TOWN AND COUNTRY PLANNING ACT 1990

Reference:	H08-0546-18	Date of Decision:	3rd September 2018
Applicant:	Mr D Scharff 59 High Street Gosberton Spalding Lincs PE11 4NJ		
Location:	59 High Street Gosberton Spalding		
Description:	Proposed residential dwelling

Drg Title: **Proposed Site
Plans**

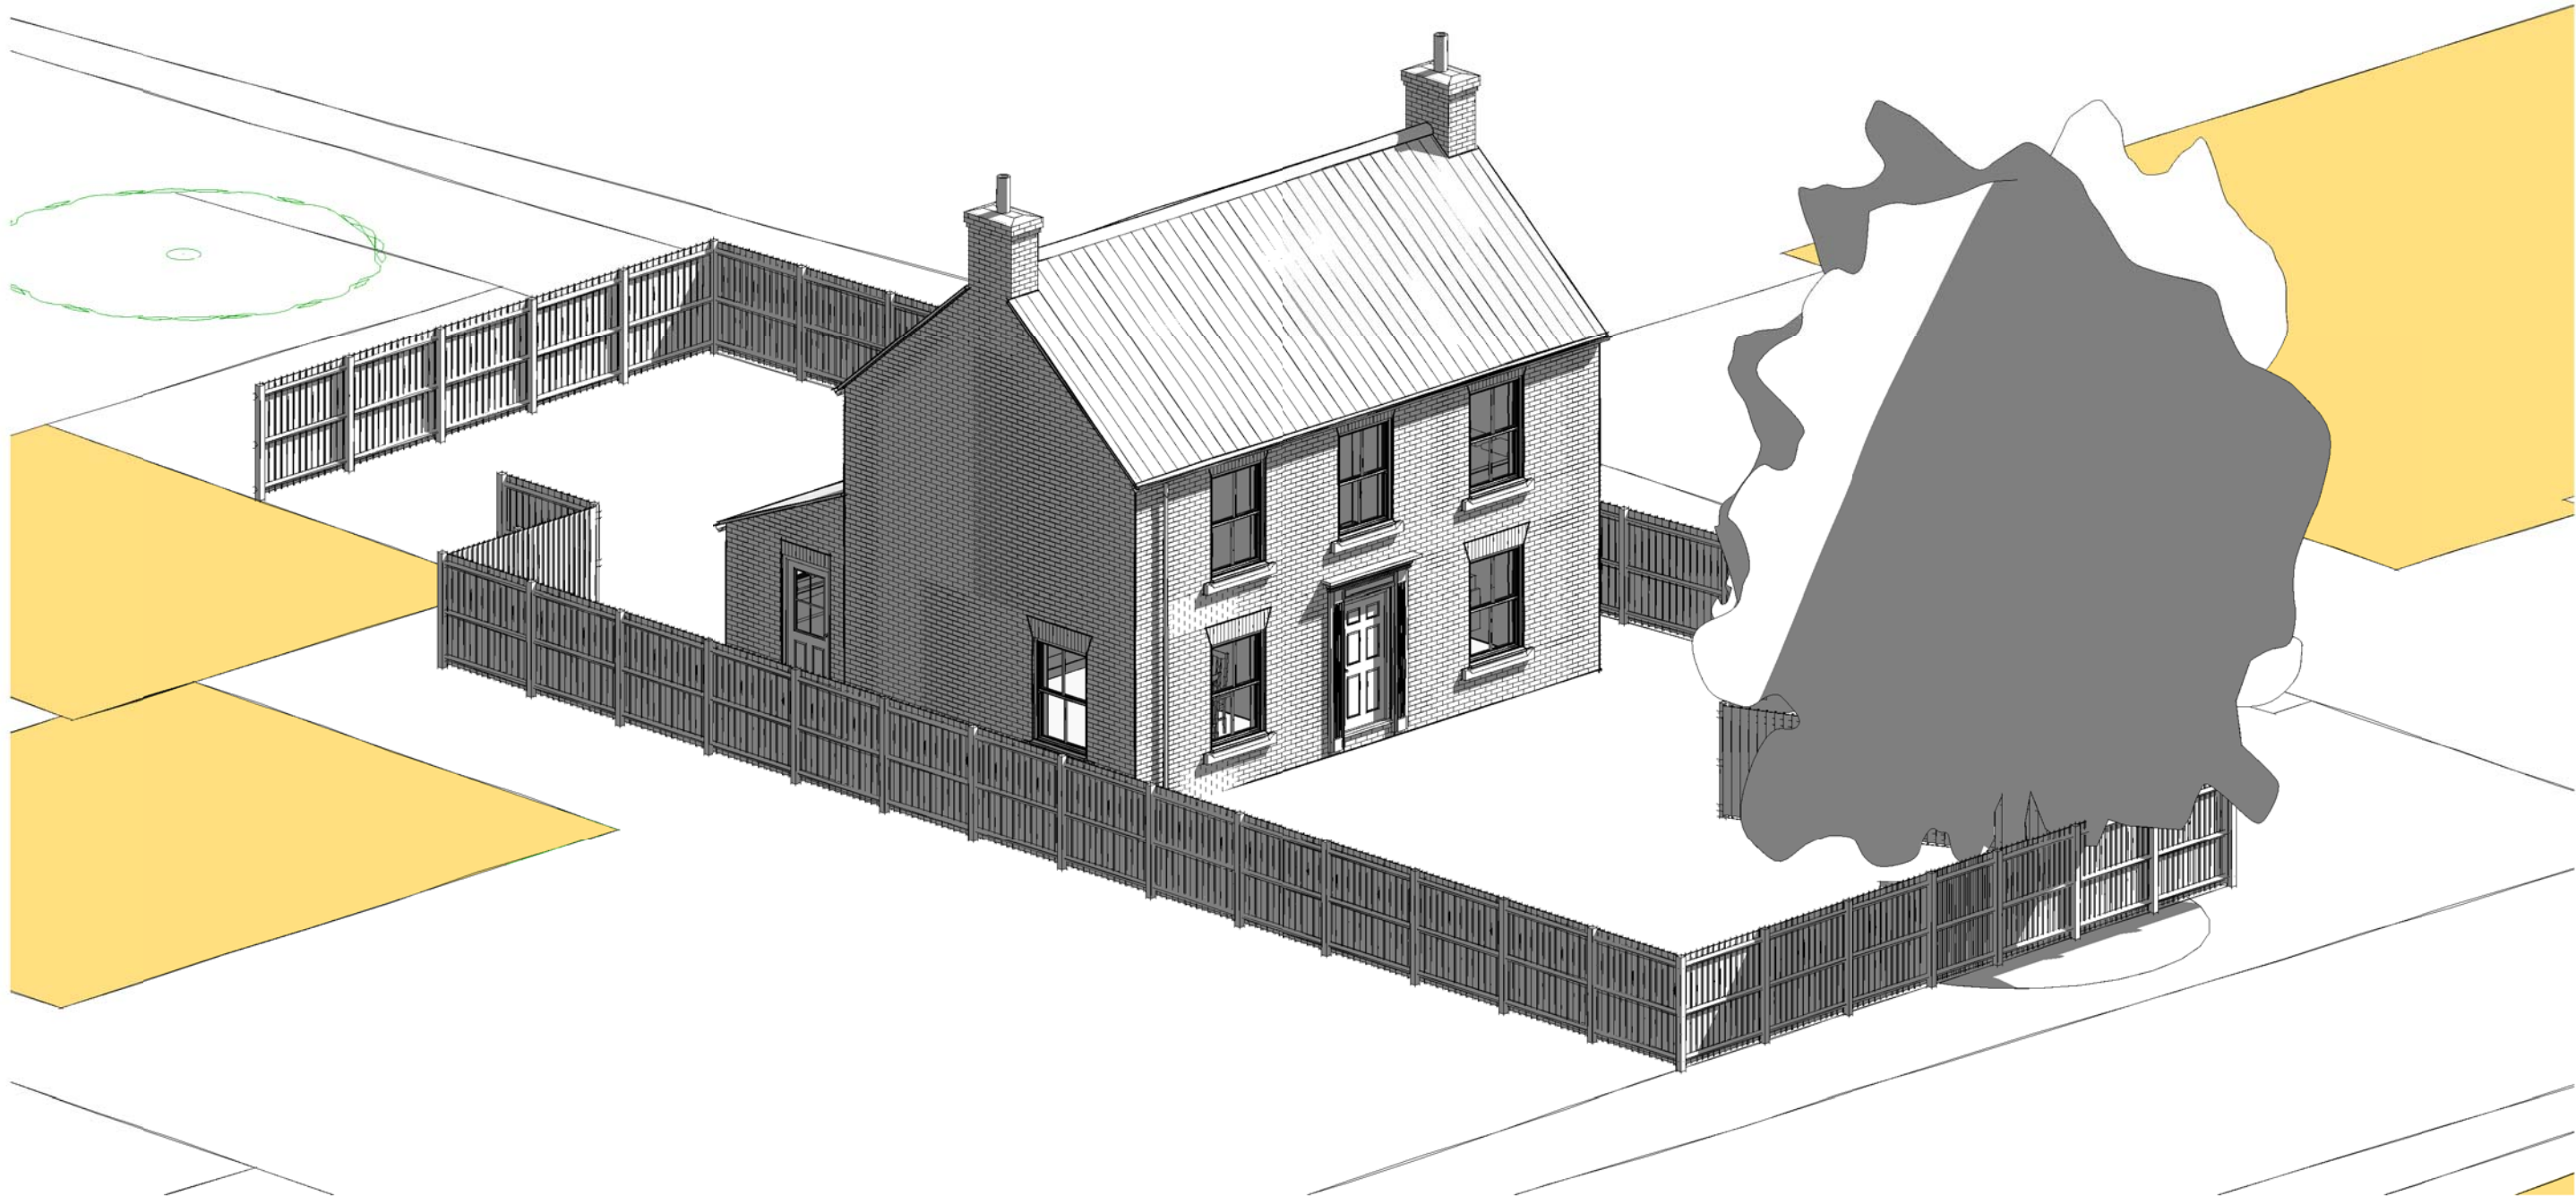
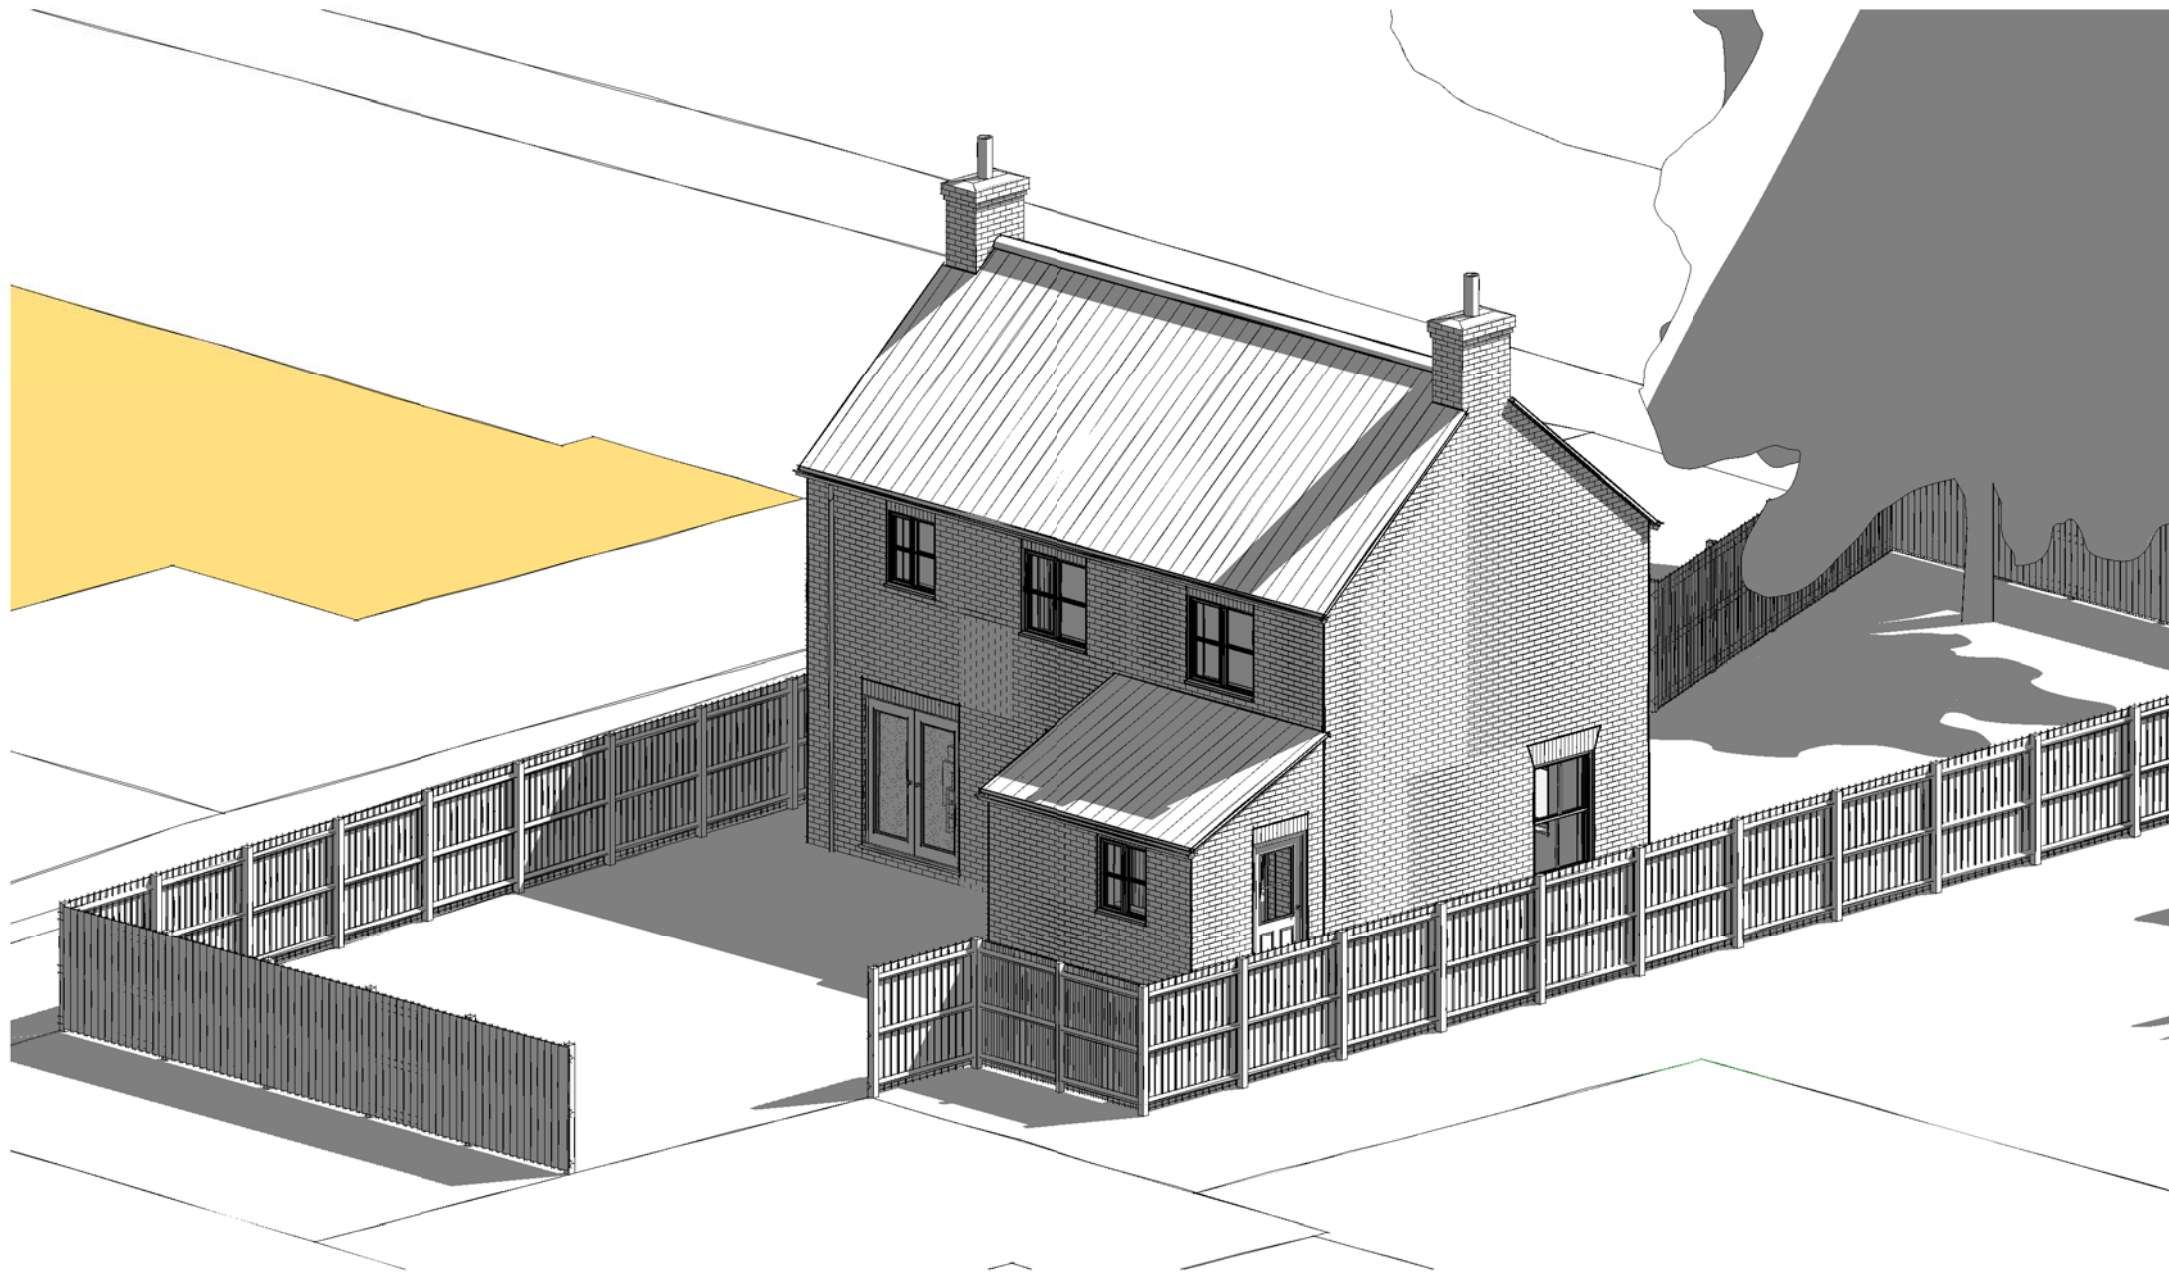
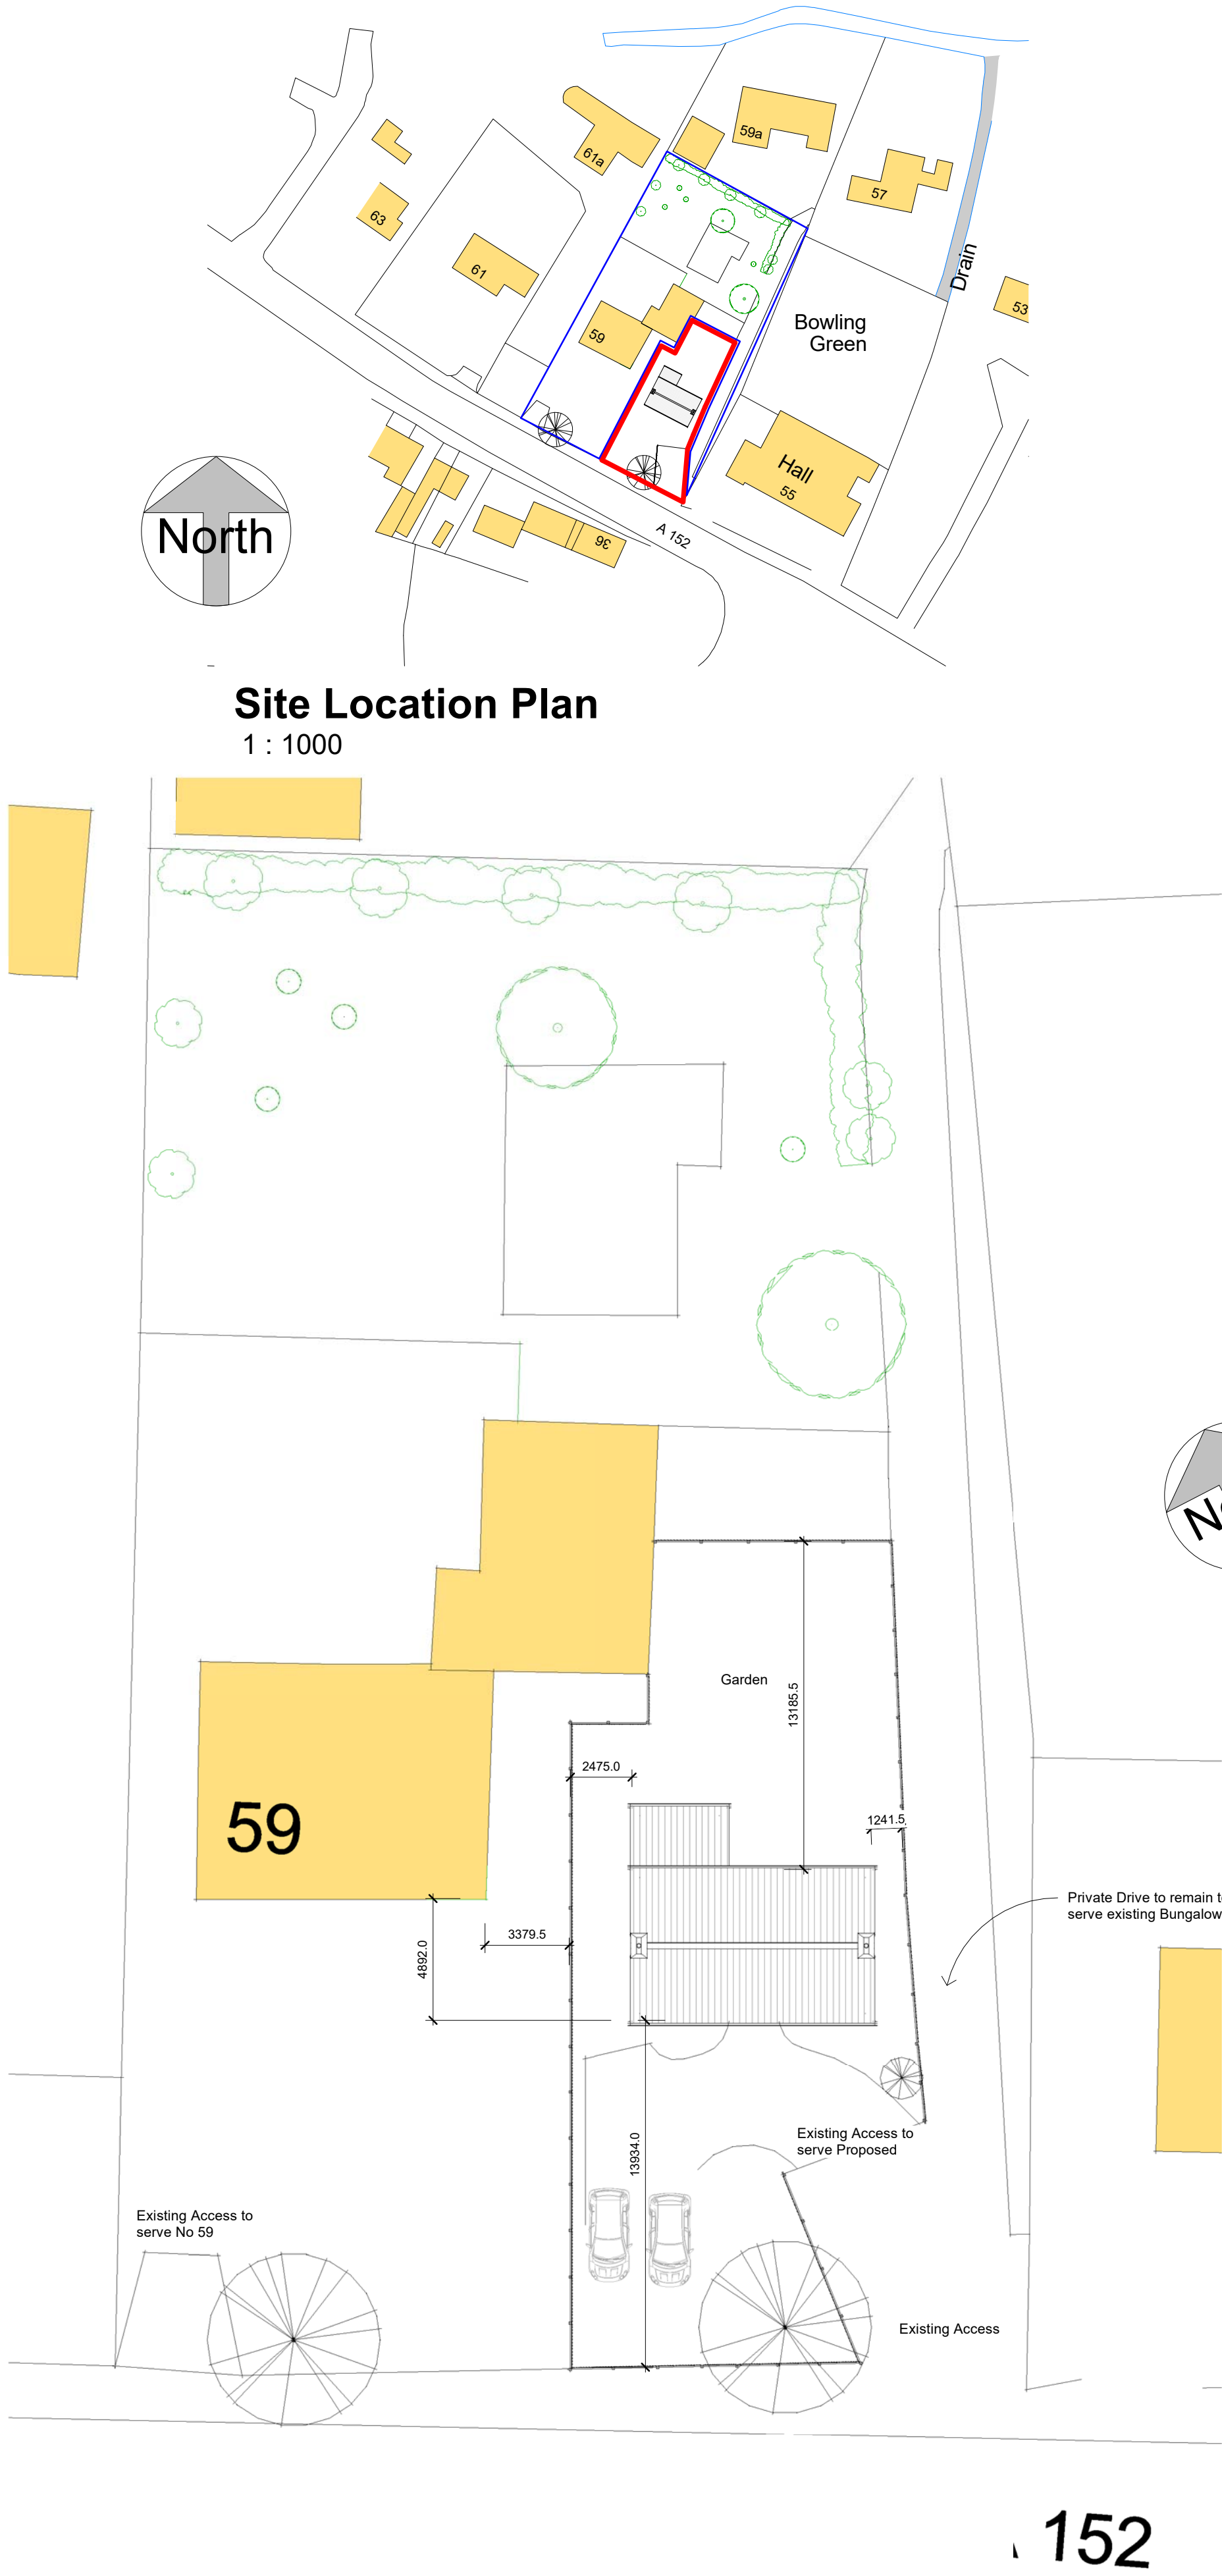
- 15 Before the commencement of the development hereby permitted, and notwithstanding the submitted details, the applicant shall submit to and have approved in writing by the Local Planning Authority constructional and surfacing details for the proposed driveway and vehicle parking area. These details shall indicate how any impact on the root system and long term health of the protected Lime tree immediately adjacent to the site access will be mitigated. The development shall be carried out in strict accordance with the details so approved.

- 17 The existing hedge along the south boundary of both the application site and No.59 High Street shall be retained and maintained at a height of 1 metre. In the event of the existing hedgerow being removed or dying, it shall be replaced to a specification that shall first have been approved in writing by the Local Planning Authority. The new hedgerow plants shall be maintained by the owner or owners of the land on which they are situated and all losses shall be made good as and when necessary.
